WEST SUSSEX COUNTY COUNCIL CONSULTATION

TO:	Arun District Council - FAO: Amber Willard
FROM:	WSCC – Highways Authority
DATE:	3 July 2026
LOCATION:	Sefter Farm Pagham Road Pagham PO21 3PX
SUBJECT:	P/76/26/PL Construction of a new engineering block building and car parking areas together with a new access road, footpaths and hard standing area. This application may affect the setting of a listed building and is in CIL Zone 5 (Zero Rated) as other development.
RECOMMENDATION:	More Information

NOTES:
© Crown copyright and database rights 2026 OS Licence AC0000855217.
Drawing based on Curtis Leeves Technical Ltd "Proposed Site Layout Plan" ref 2601-P005 Rev 04, dwg received 19/05/26

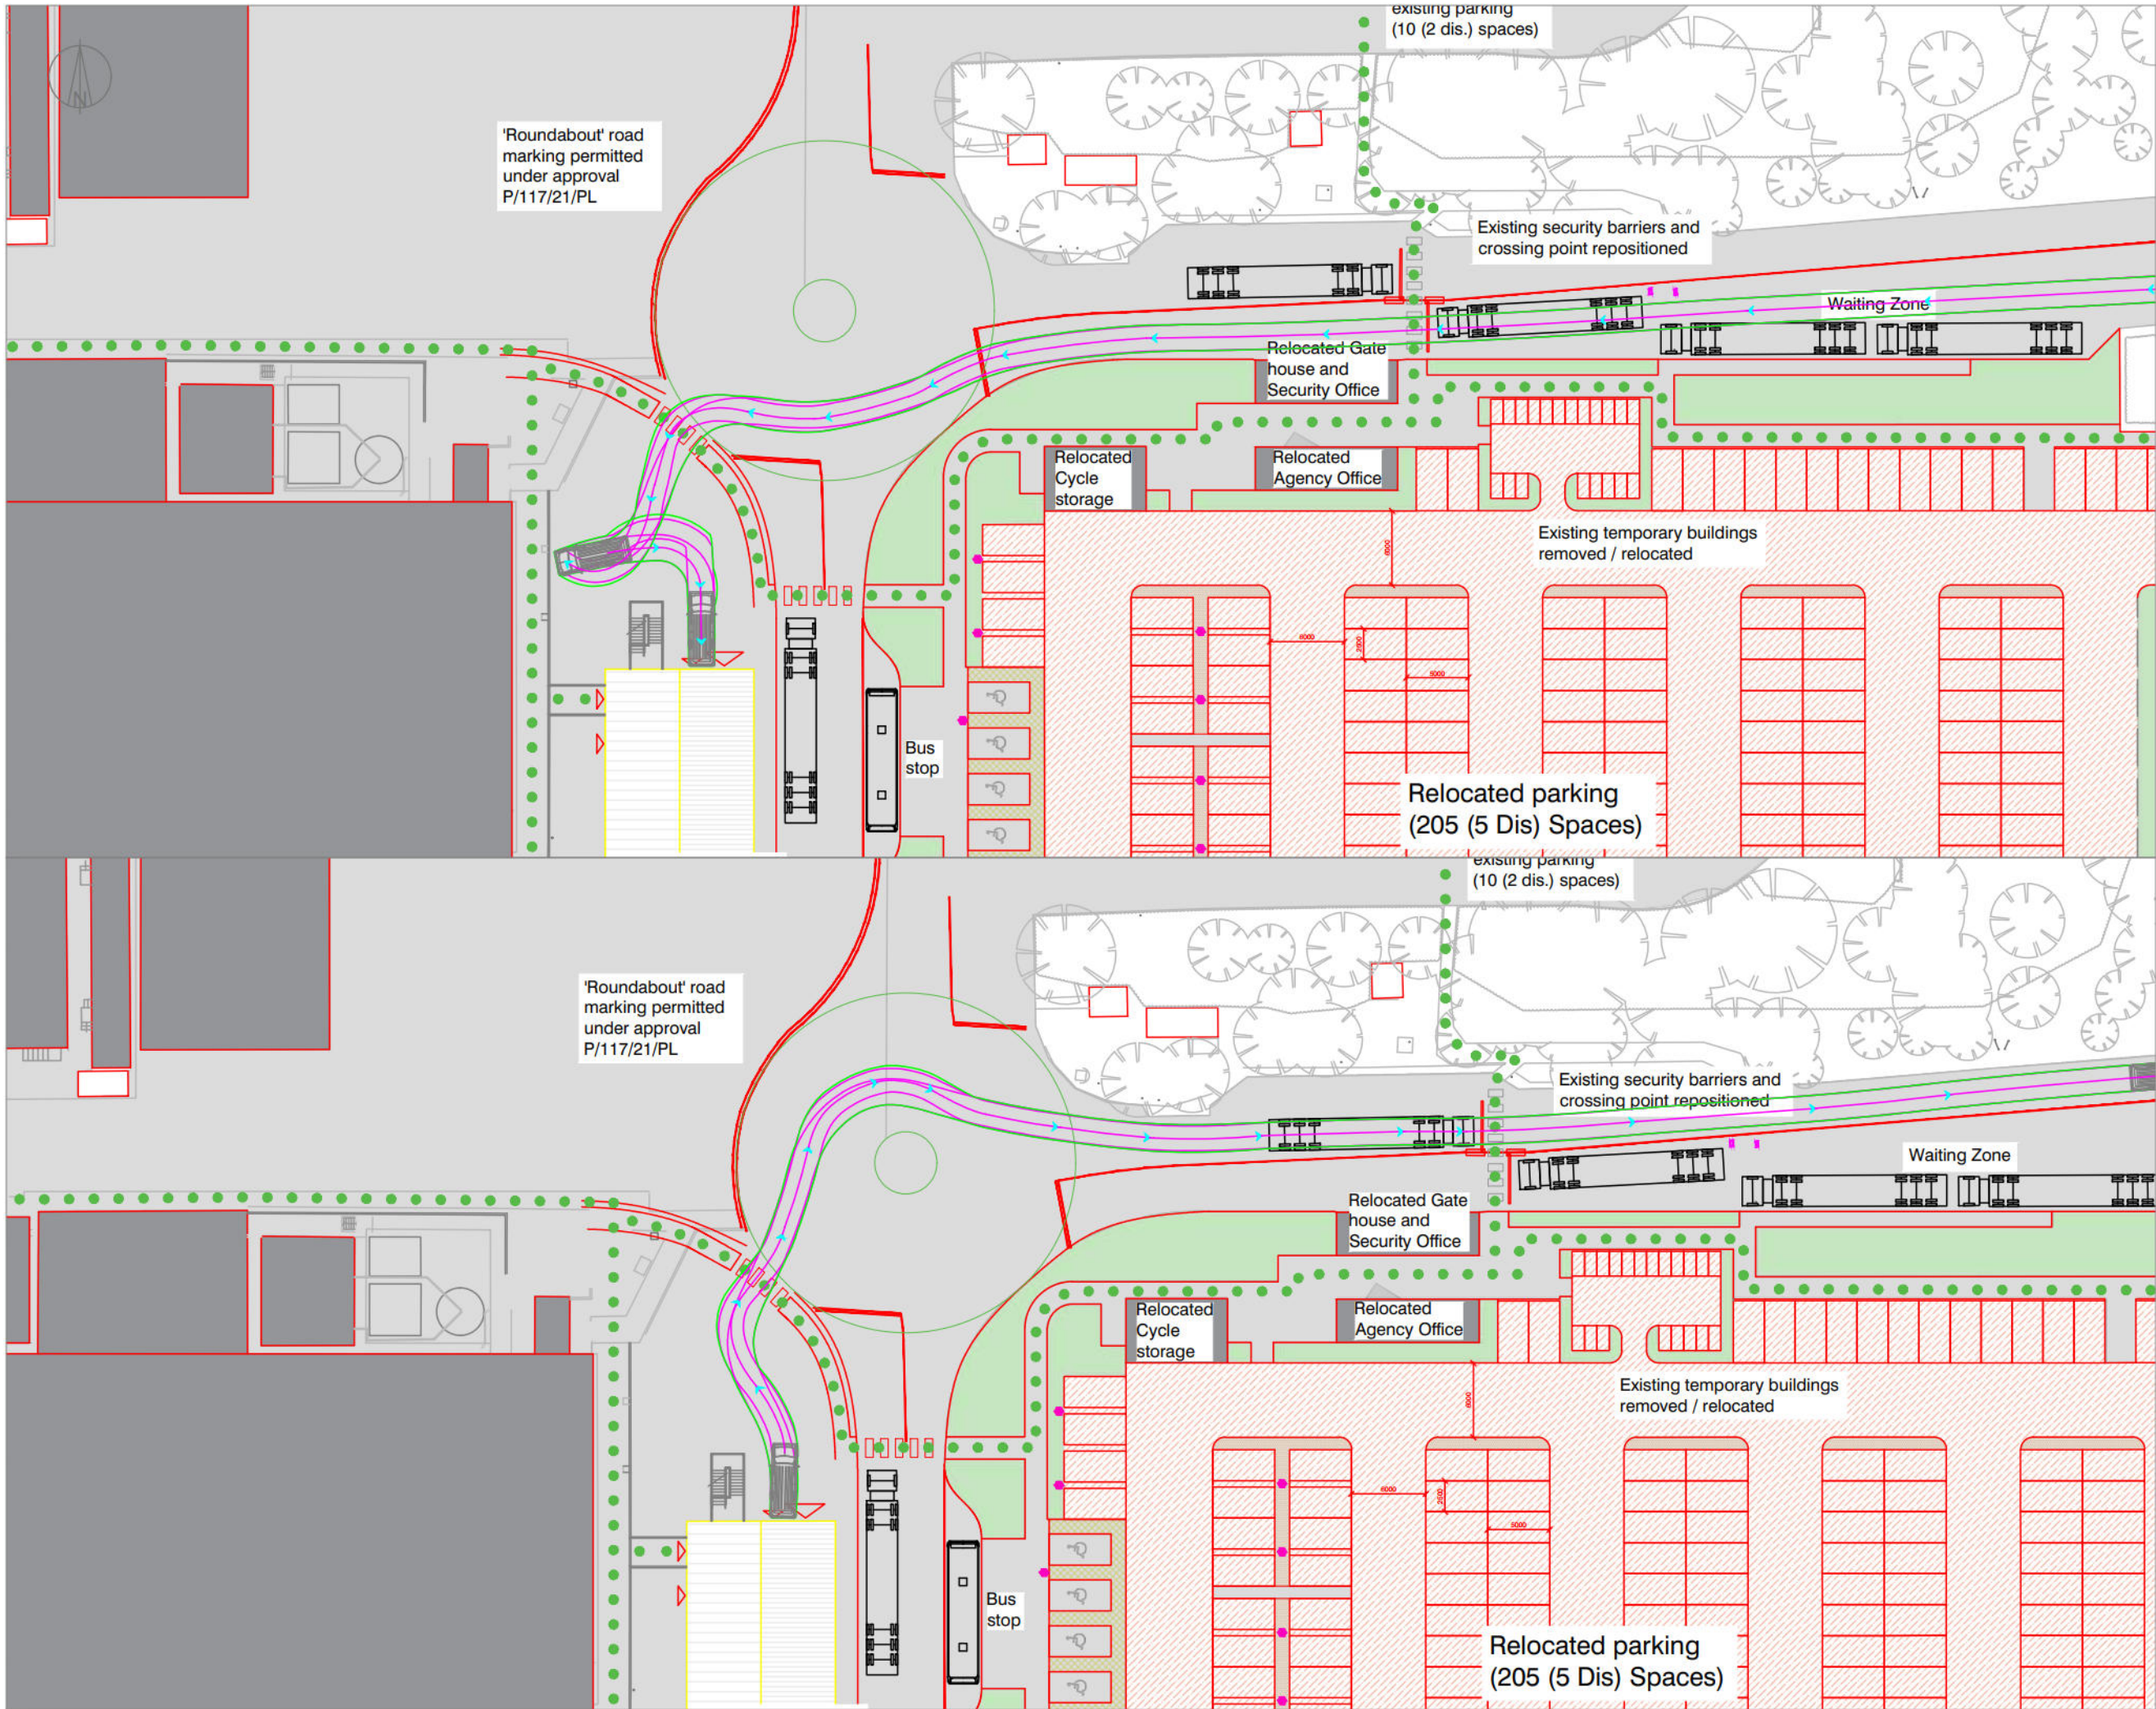
Whilst the site is rural and no cycle infrastructure on nearby roads exist, there is a bus stop to south at junction with Sefter Road with Chichester/Bognor service. However, Barfoots runs a bus service from within the site with services to Bognor/Littlehampton and Portsmouth for shift worker start/finish times. The internal bus stop will be relocated from along the main access road to west of the car park. It is advised that swept path tracking is provided to demonstrate workability including turning for bus.

- Updated TP.
- Swept path tracking for bus for new bus stop location, including turning on site.

Visibility Splays at Car Park Accesses

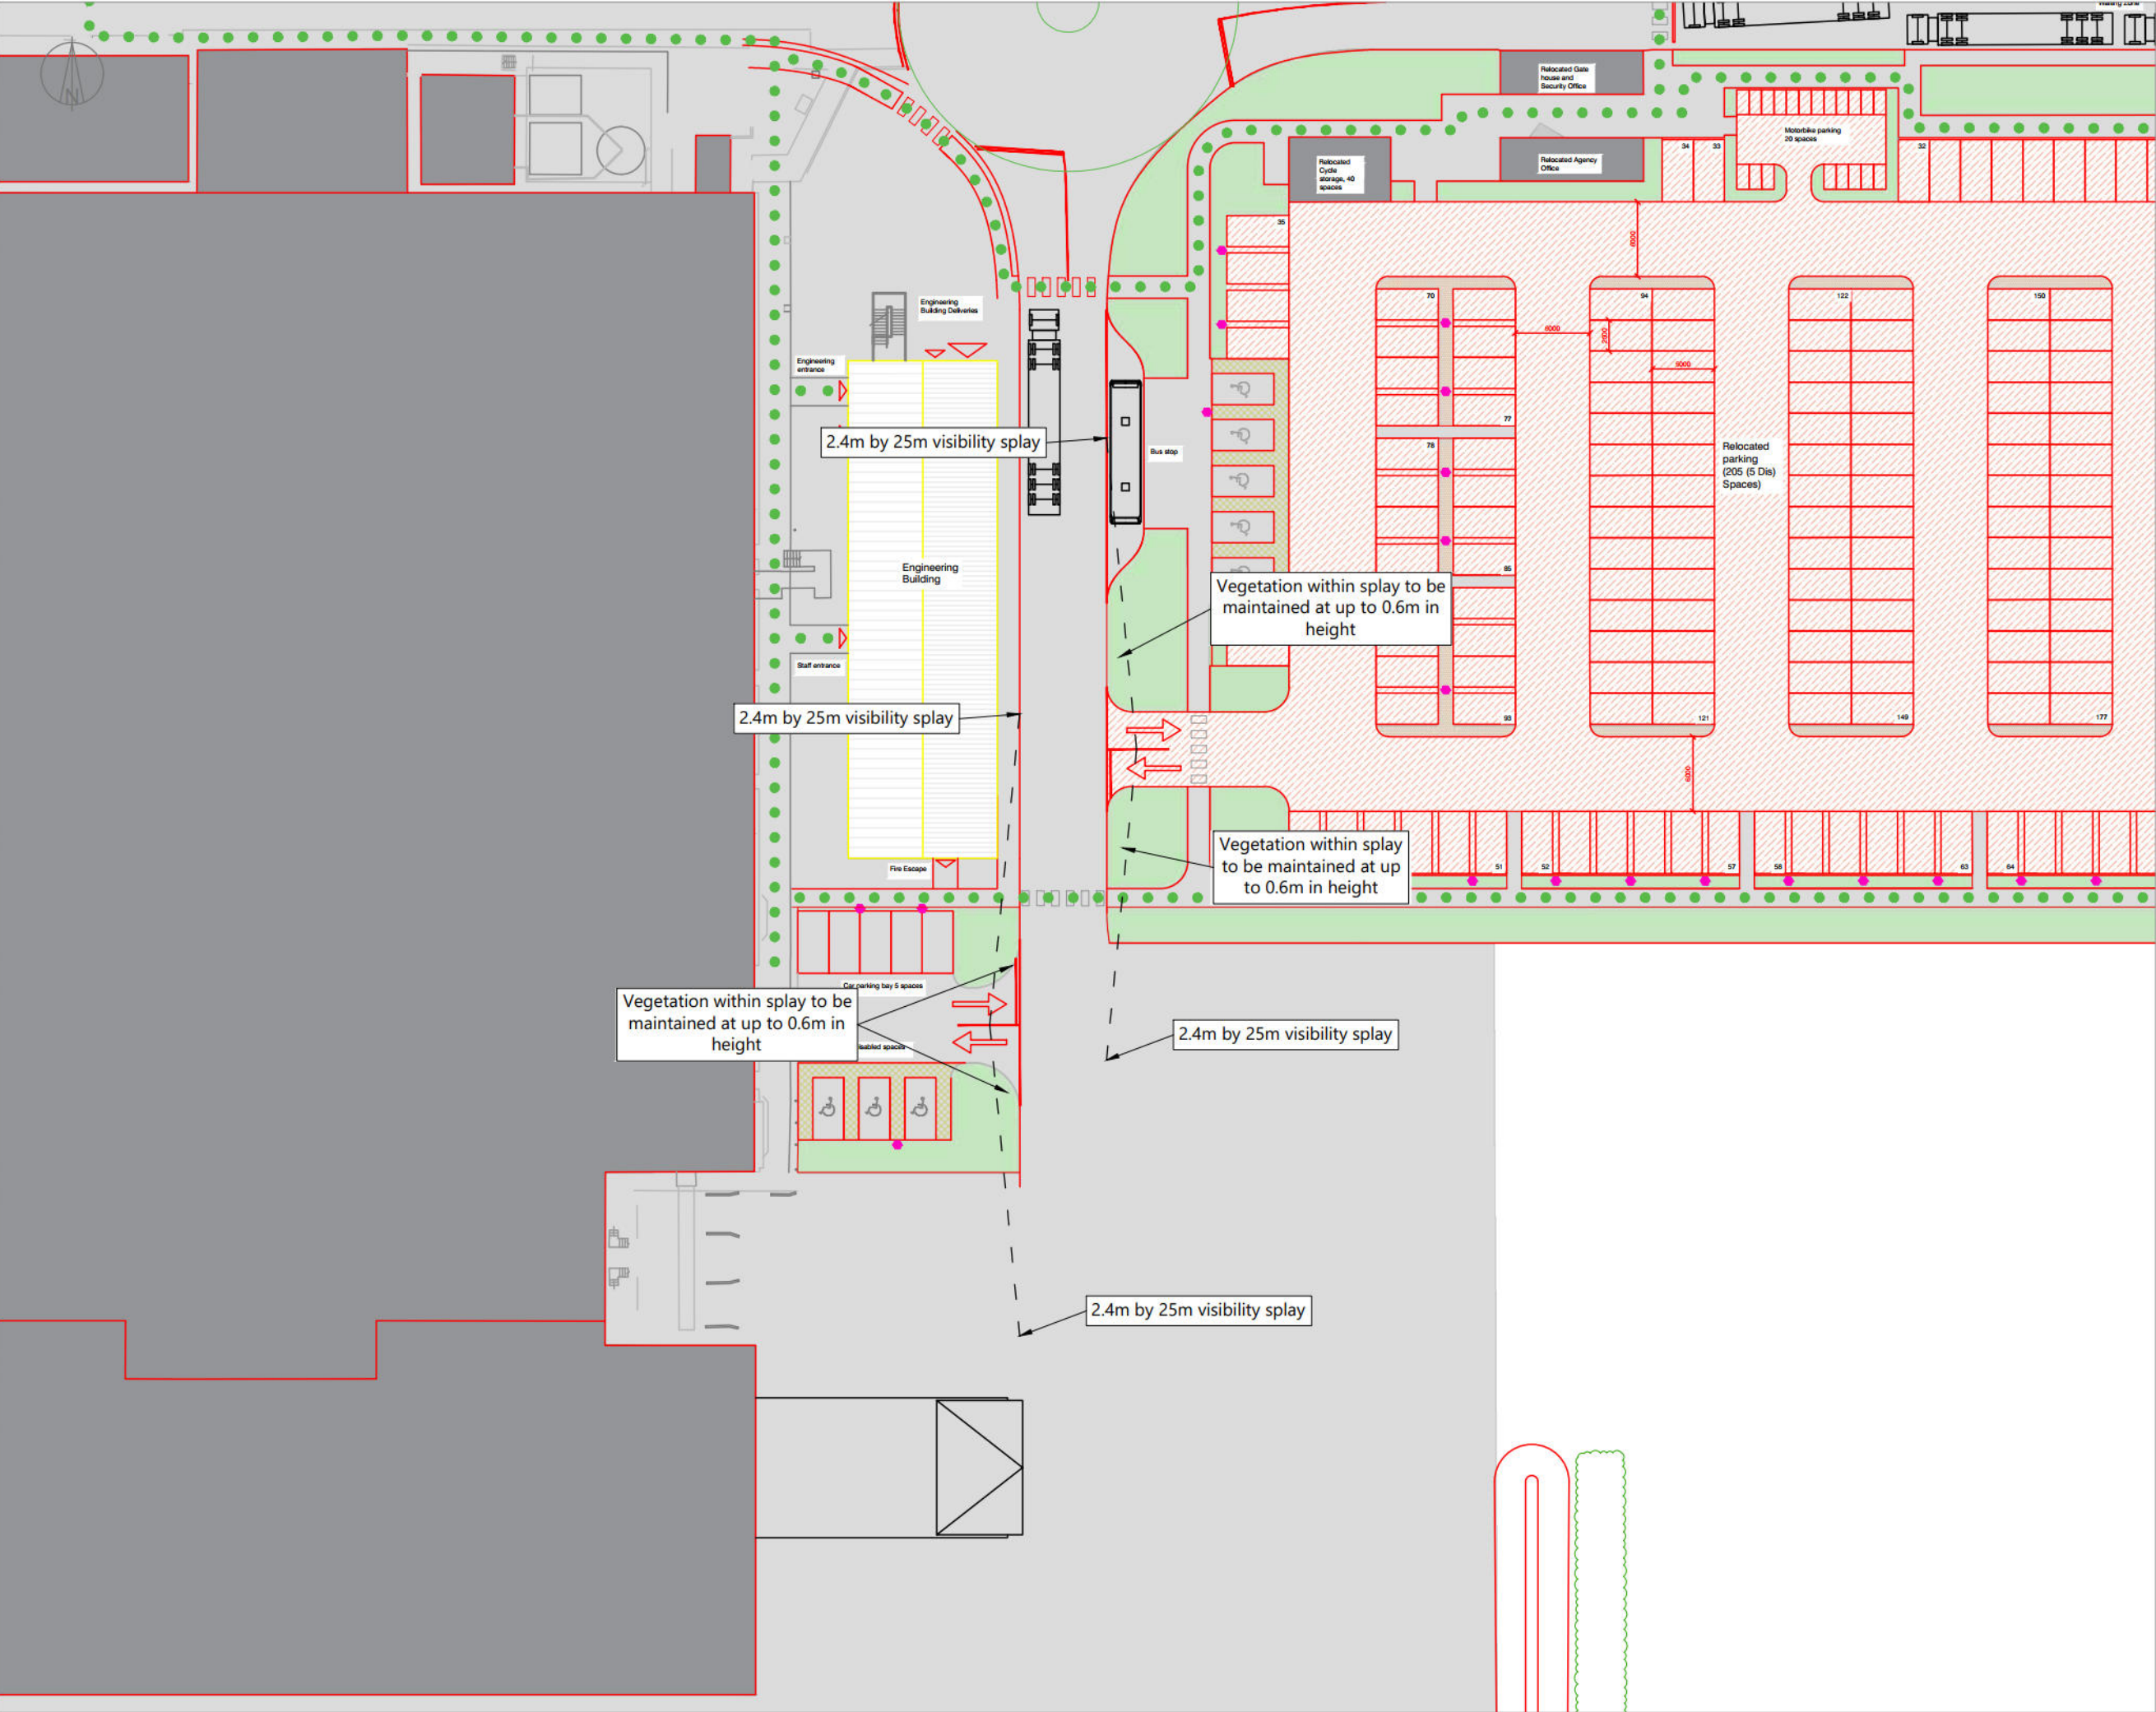
Swept path tracking shows the car park access and egress points are workable and internal visibility splays within site are achievable to a 20mph design speed (25m) for the car parking areas accesses on to internal access roads.
